Haley Rich - Re: Orica Kooragang island: Modification application

I have reviewed the modification application for the Orica Kooragang Island AN Facility (08_0129 Mod 1).

Figure 3-16: Site IFR - MOD 1 (v6.7)

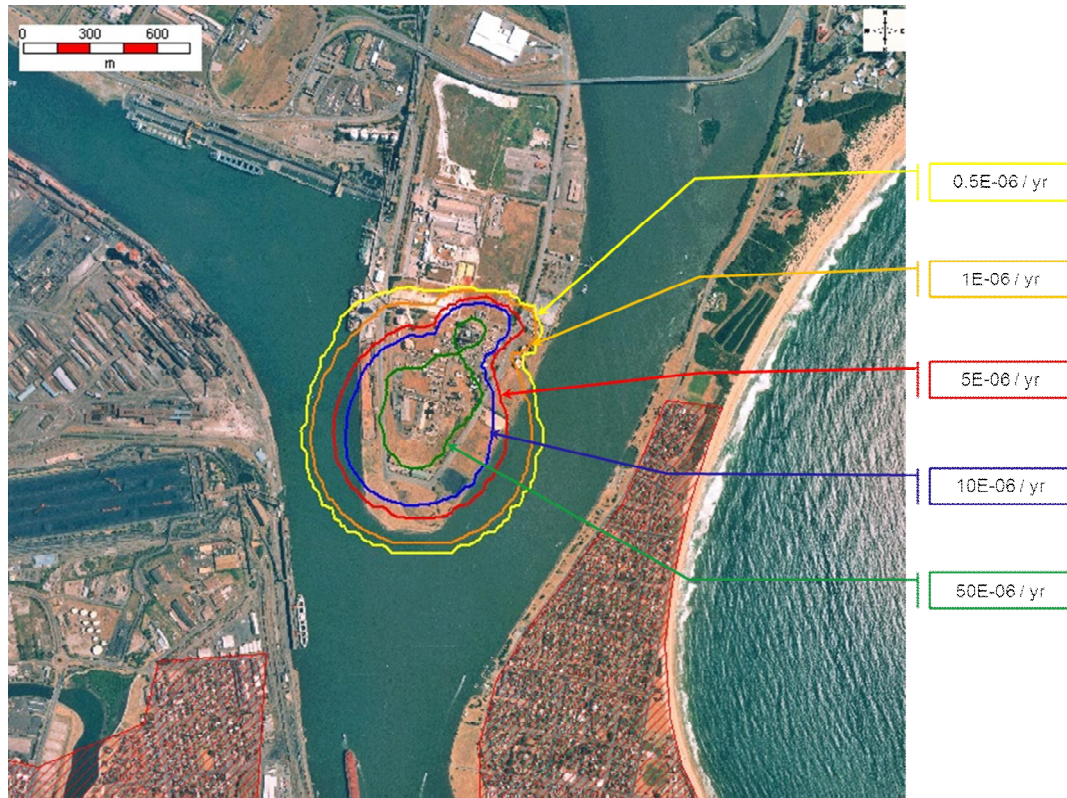
I have a concern that the Orica modification has increased the IFR risk from 56E-06 to 60E-06pa at the northern boundary (see Table 1 in PHA MOD 1 Report). The modification should not increase the level of risk with the Incitec Pivot boundary.
